RE: [External] 68-80 Beauchamp Road, Hillsdale - Feasibility CN226021 Response

Please find our response to the documents submitted under trailing email.

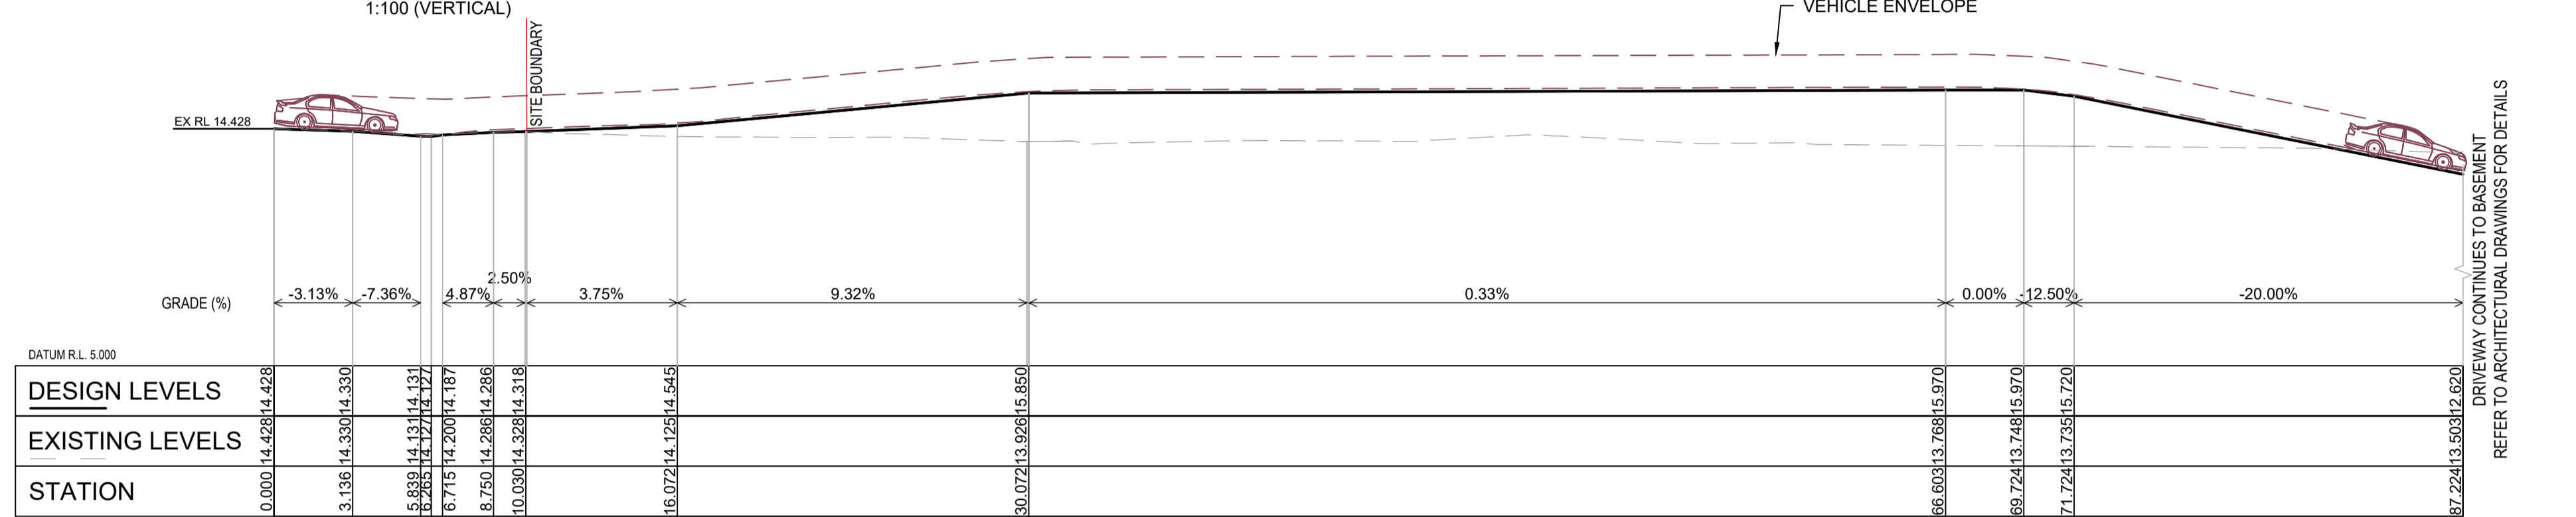
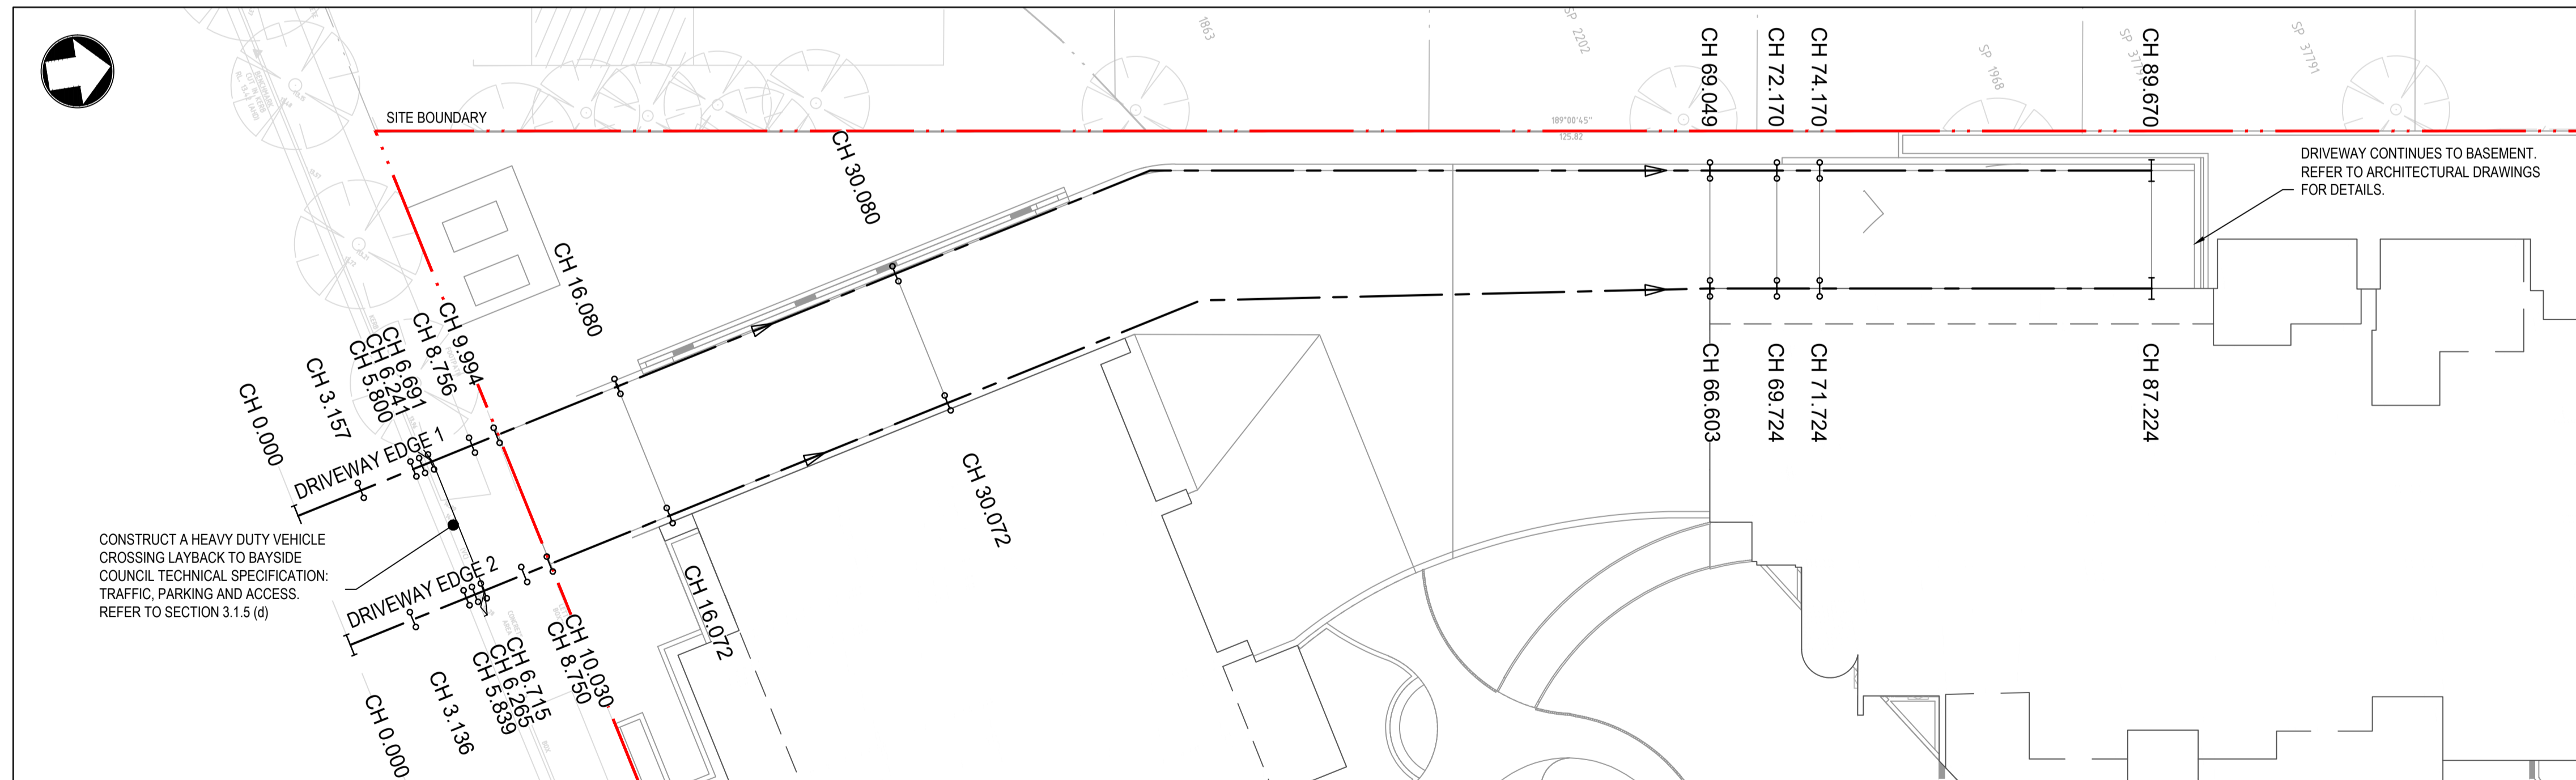
- Sydney Water has no objection to the proposed works in principle. However, the proponent must ensure that the width of the driveway or pedestrian crossing is not increased beyond what has already been proposed.

Client	HOMES NSW
Project	68-80 BEAUCHAMP RD, HILLSDALE
Title	GROUND FLOOR PLANTING PLAN
Original Size	A1
Drawing No:	LD-DA200
Rev:	2

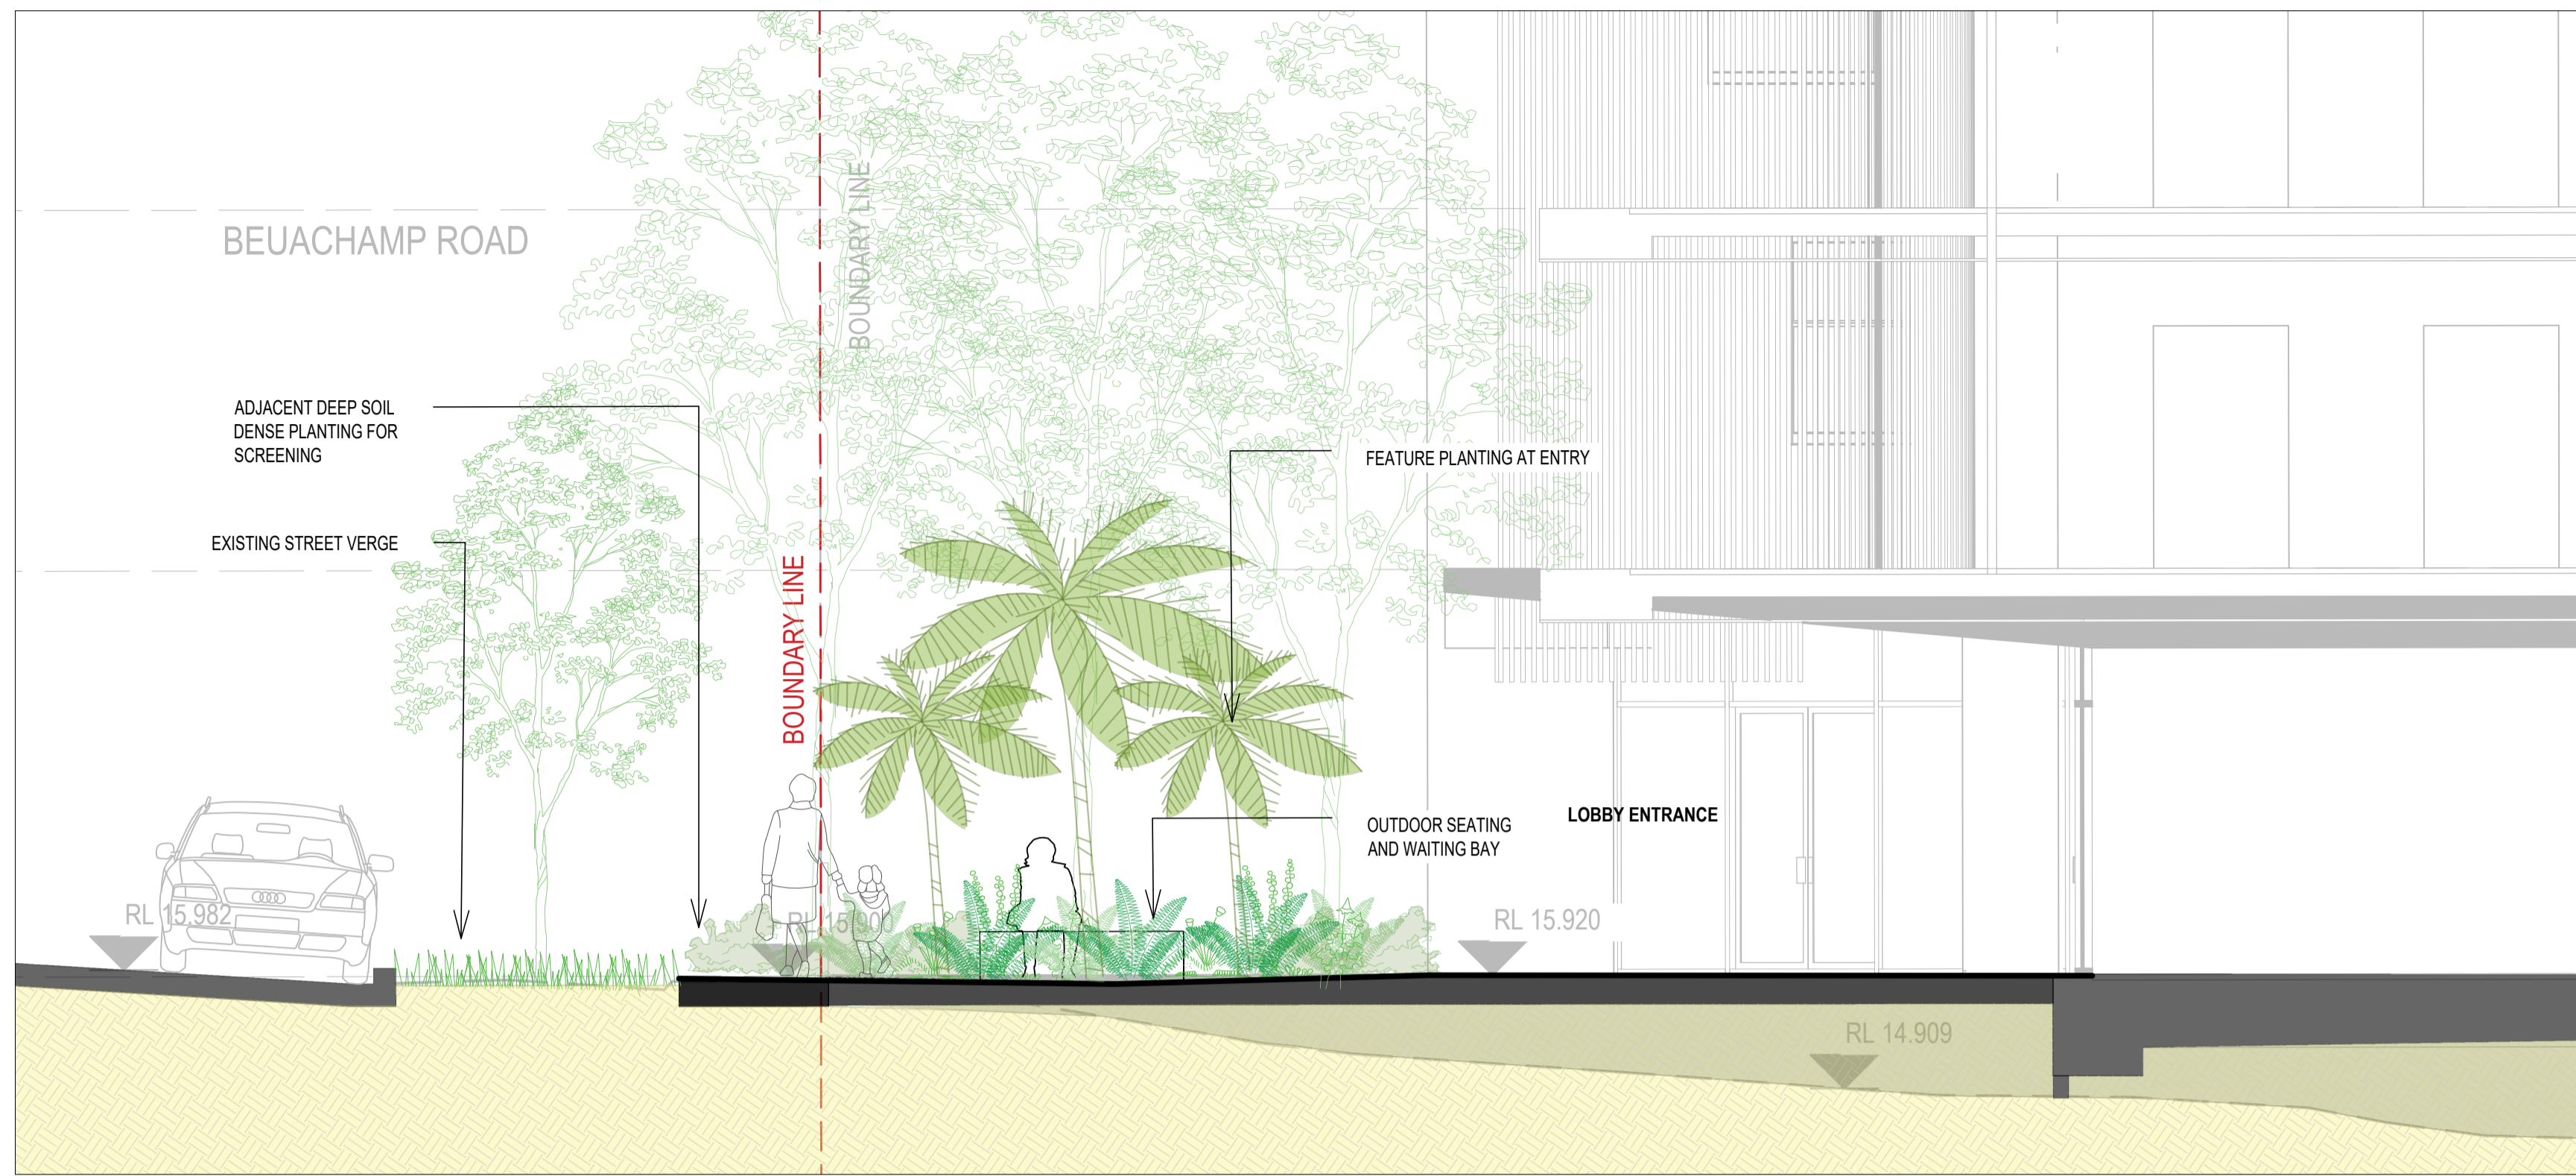
- Landscaping works over Sydney Water's stormwater channel should be minimised. Any planting must comply with Diagram 5 – Planting Trees of the Technical Guidelines – Building Over and Adjacent to Pipe Assets.
